## Portland Water District

July 26, 2016

Attn: Jon Whitten  
Re: 30 Merrill Street - Portland  
Ability to Serve with PWD Water

C1

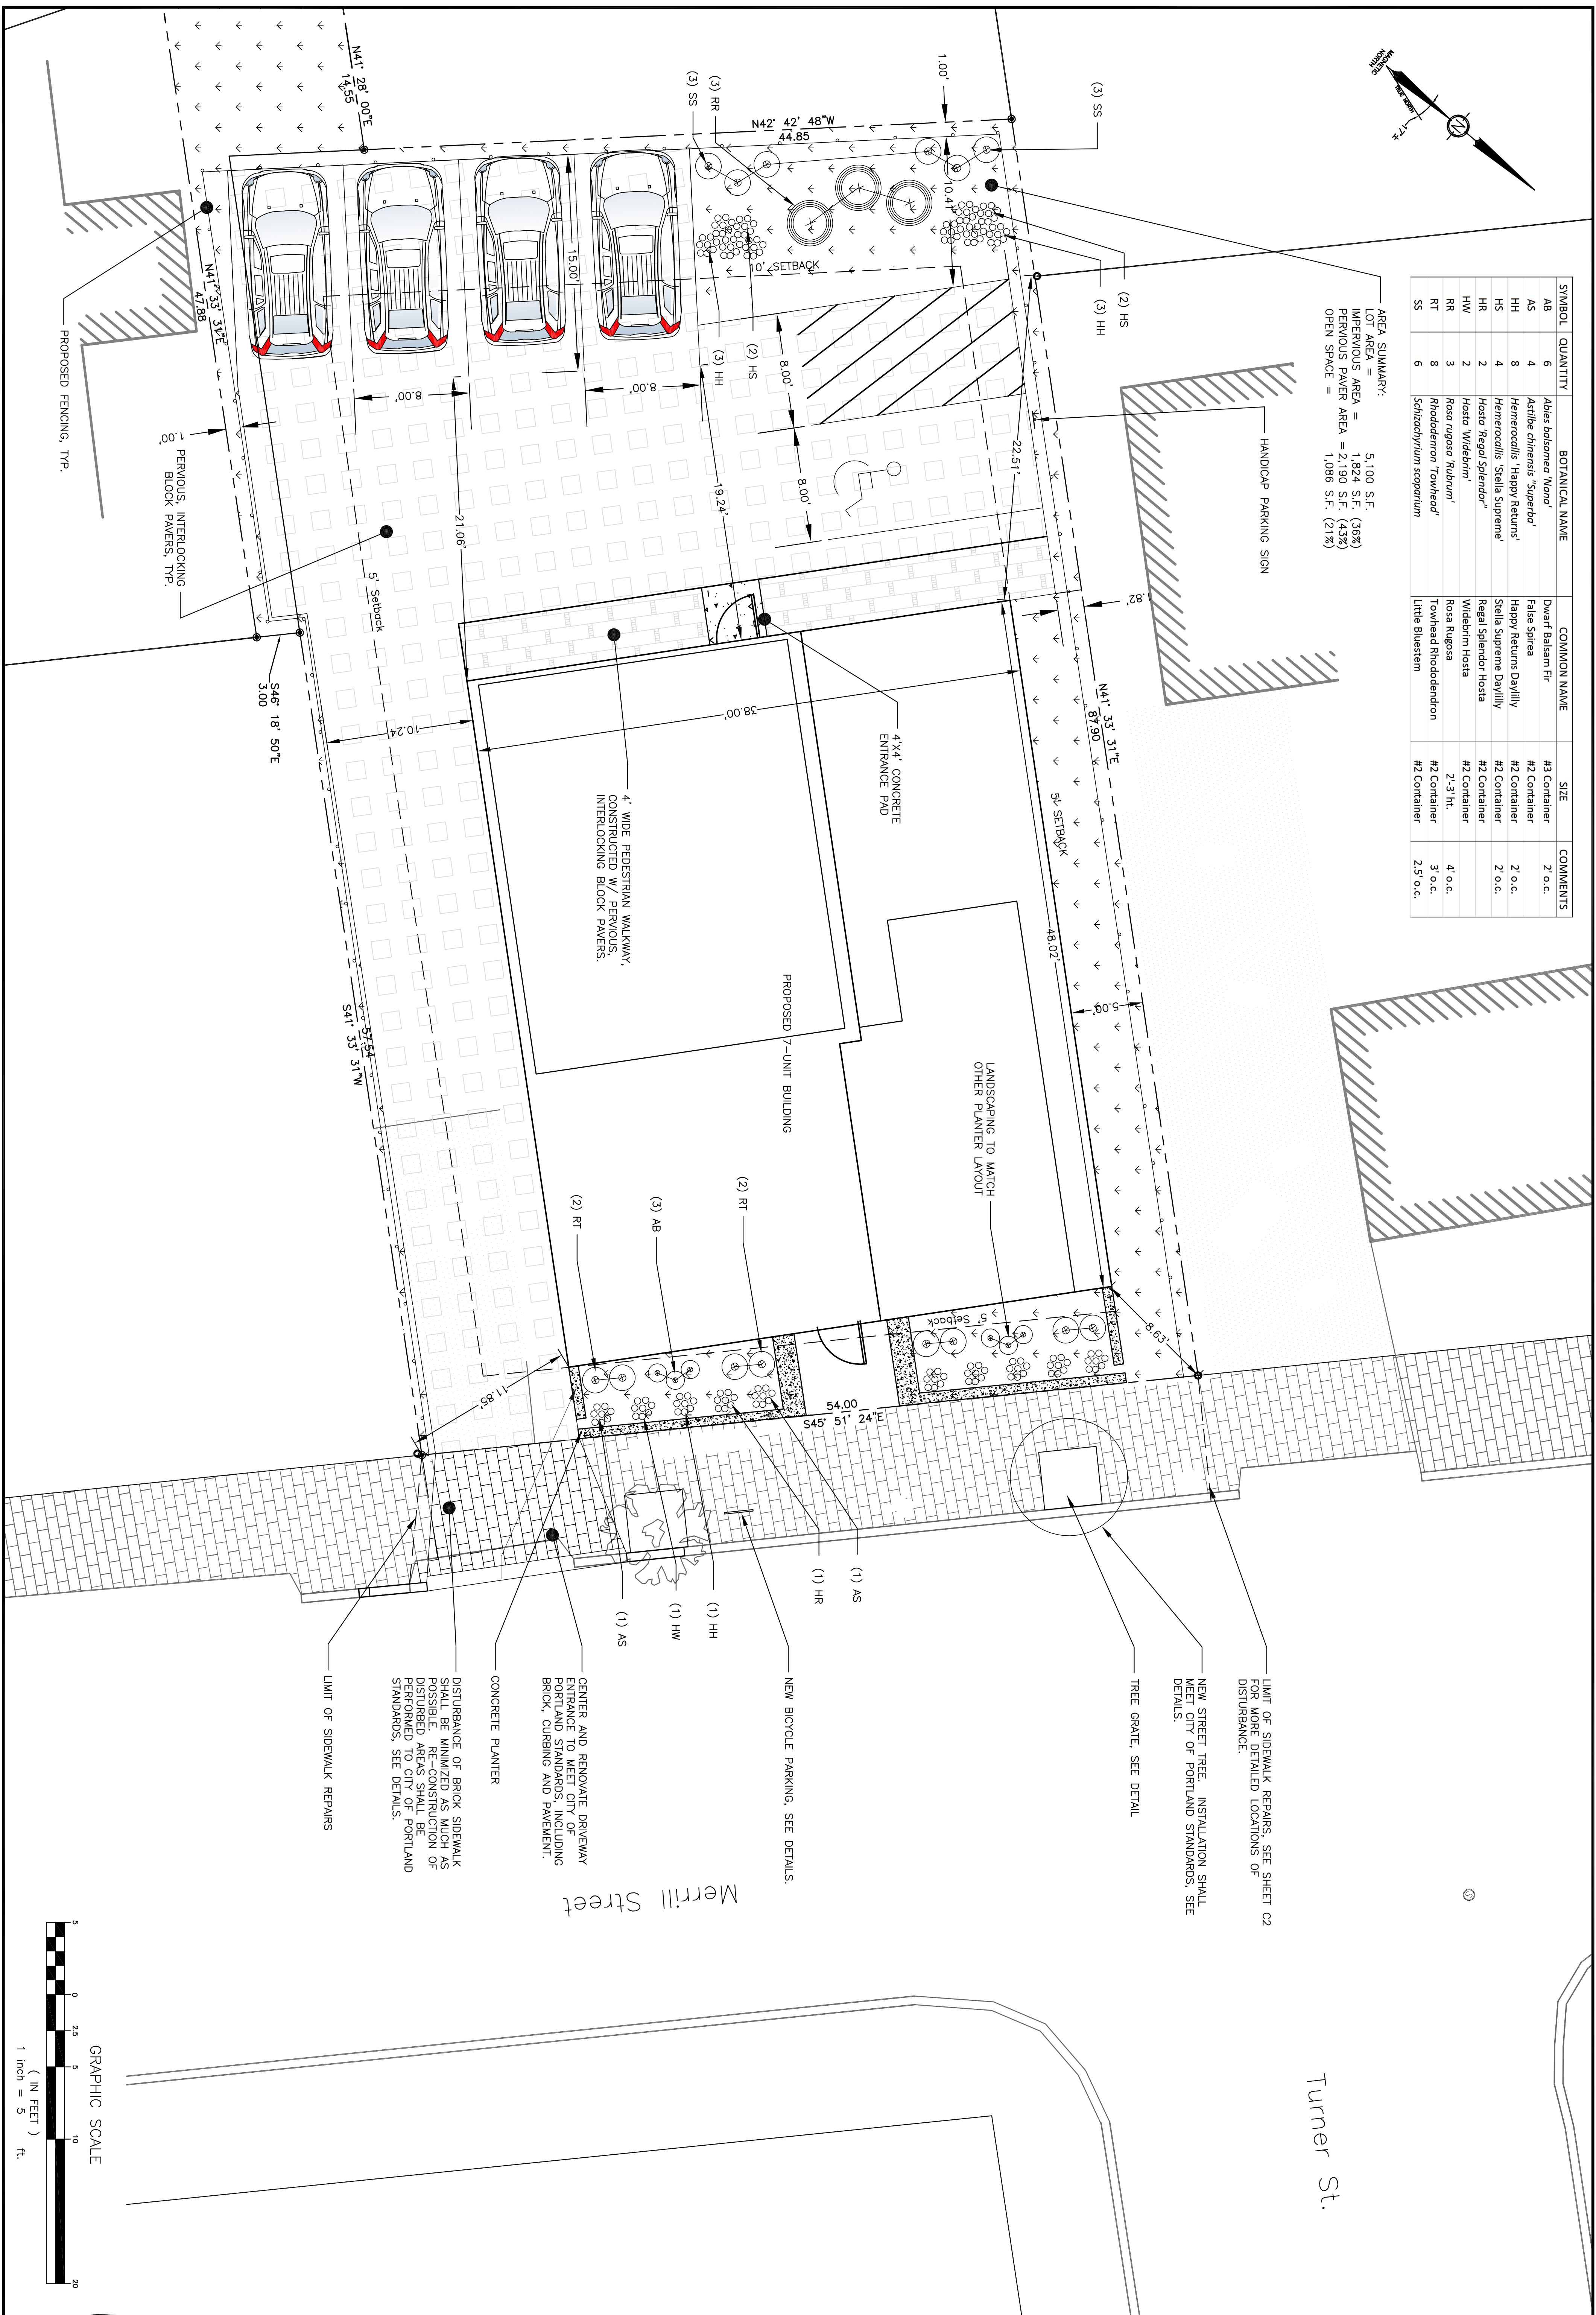
- A new 4" fire service may be installed from the water main in Merrill Street. A 2-inch domestic service may be tapped off the 4" fire service just before the street line as shown on a plan entitled Seven Unit Building, 30 Merrill Street, Sheet C1. Based on the fixture count you provided, we have calculated a peak flow of 25 gallons per minute. A 3/4" meter will accommodate this flow.

- We will need written confirmation from the sprinkler company that this configuration is acceptable to them.
- The existing building is currently served with a 3/4-inch domestic water service. The size of this service is undersized for the proposed use. This service must be terminated by shutting the corporation valve, cutting the pipe from the water main and removing the curb stop.
